PL- Consultation- Conservation Officer response

Y/42/26/L

Address: Bonhams Farm House Main Road Yapton BN18 0DX

Proposal: Listed building consent to add channel drain across the front elevation in front of the stable space, add wood floor and battens over new bed2 (former garage) and stable floor, replace main stable door with compliant painted double glazed timber door in similar style but with glazed panels in the top half and add removable slimline secondary glazing inside 3 retained timber windows in the stable space (resubmission following Y/39/25/L).

Long Section proposed

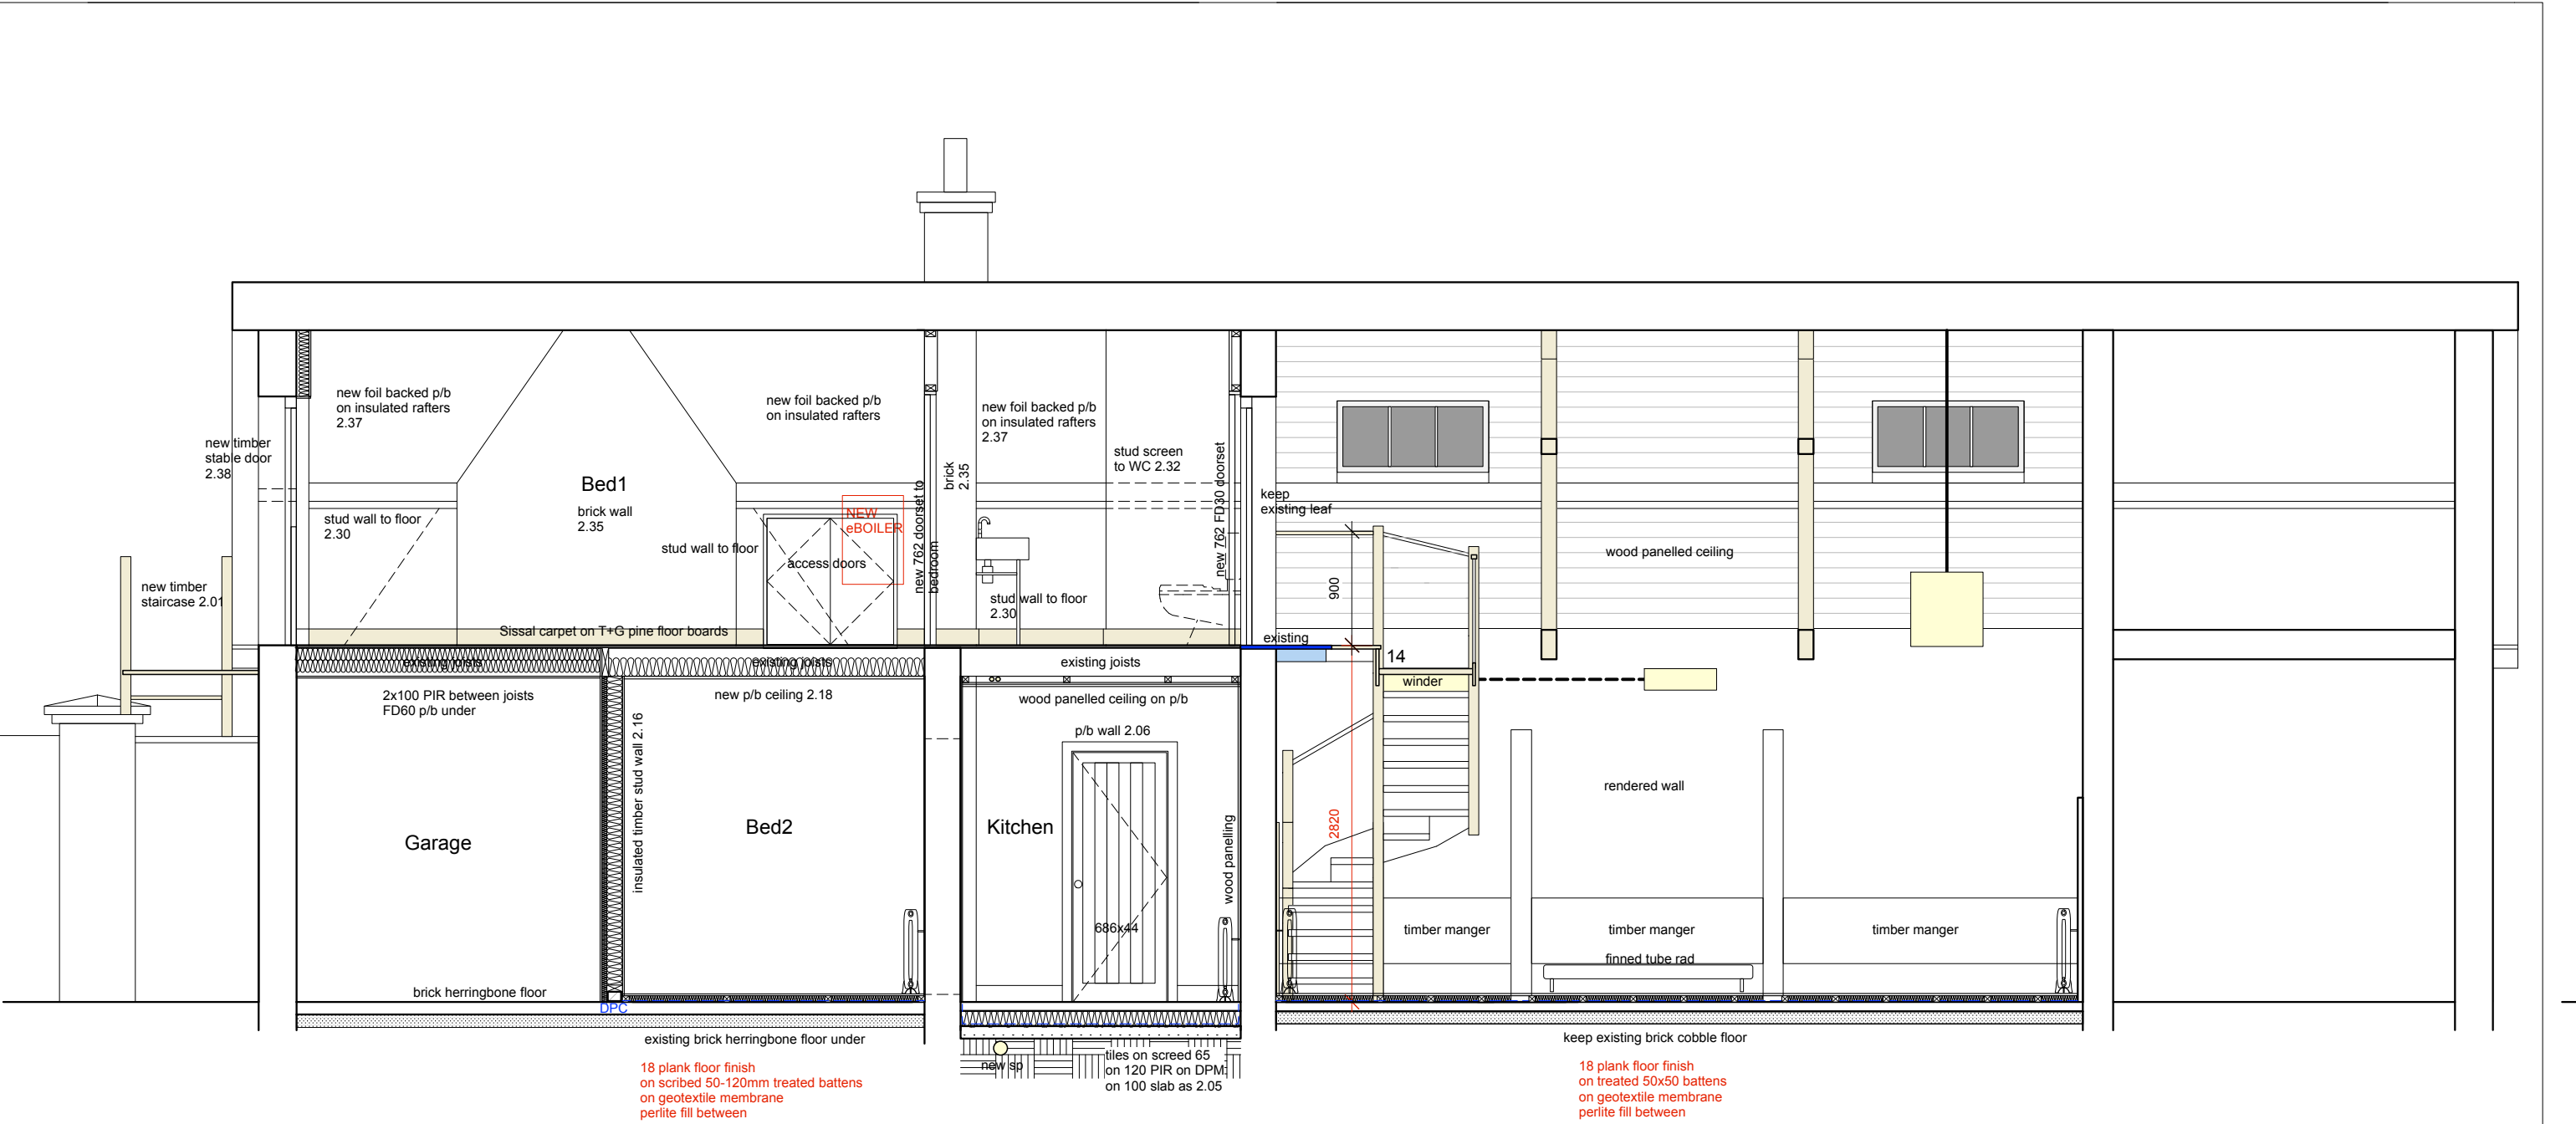
I would also wish to be reassured that the proposed timber flooring would not cause any harm to the existing floor, which is to be retained beneath. For instance, will it enable the floor to breathe and therefore not deteriorate as a result of trapped moisture? I would also want to be assured that no fixtures or fittings will be attached to the brick cobbles.

Further information is required in the form of a revised elevation and details of the proposed flooring before I can conclude a level of harm.

Garage / new bedroom2

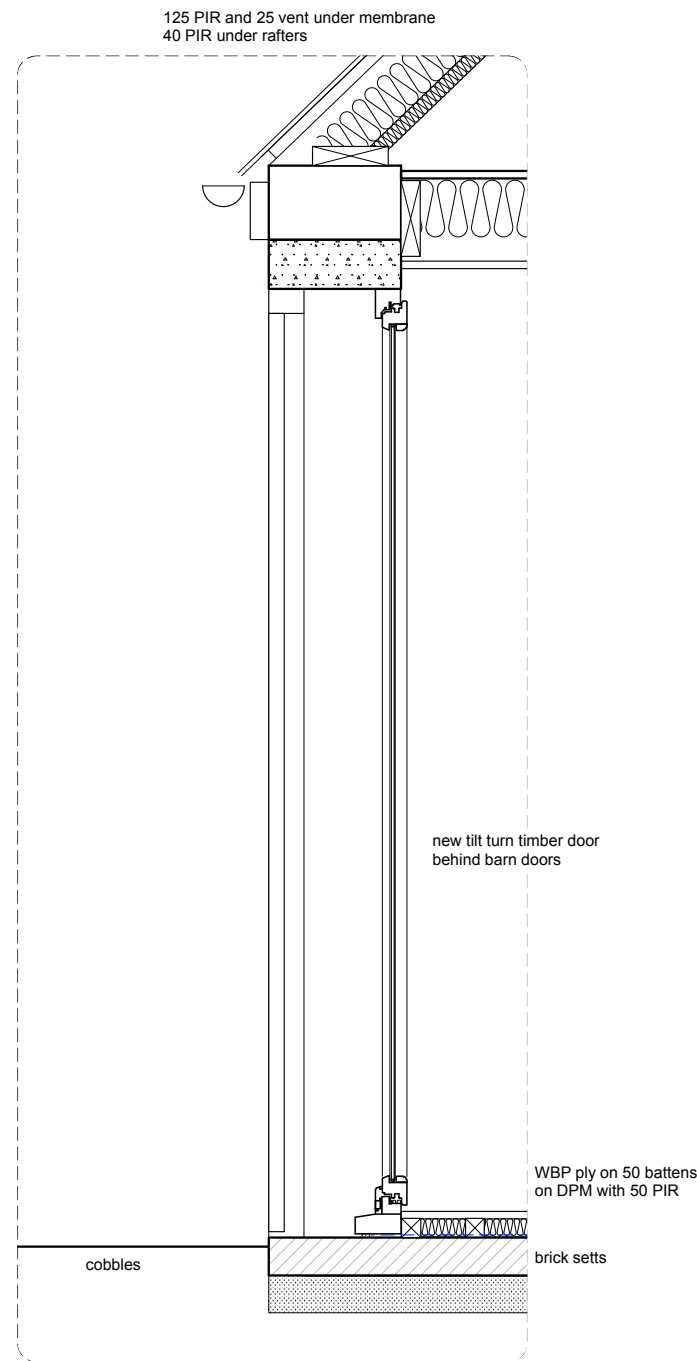
Whilst the revision to the approved scheme would look to be acceptable, it is not clear what the double-glazed timber door/window behind the garage doors would look like, as no elevations have been provided and only the closed garage doors are shown on the submitted drawings. Likewise, I will need to see further information on the new stable door. I have requested a condition.

Prior to their insertion details of the windows and doors including their design/appearance (including elevation), specification, glazing bars, glazing (system), method of opening, decorative/protective finish (i.e. stain/paint and colour) and location within the reveal, in the form of drawings and sections of an appropriate scale, shall be submitted to and agreed in writing by the Local Planning Authority before the windows and doors are installed.
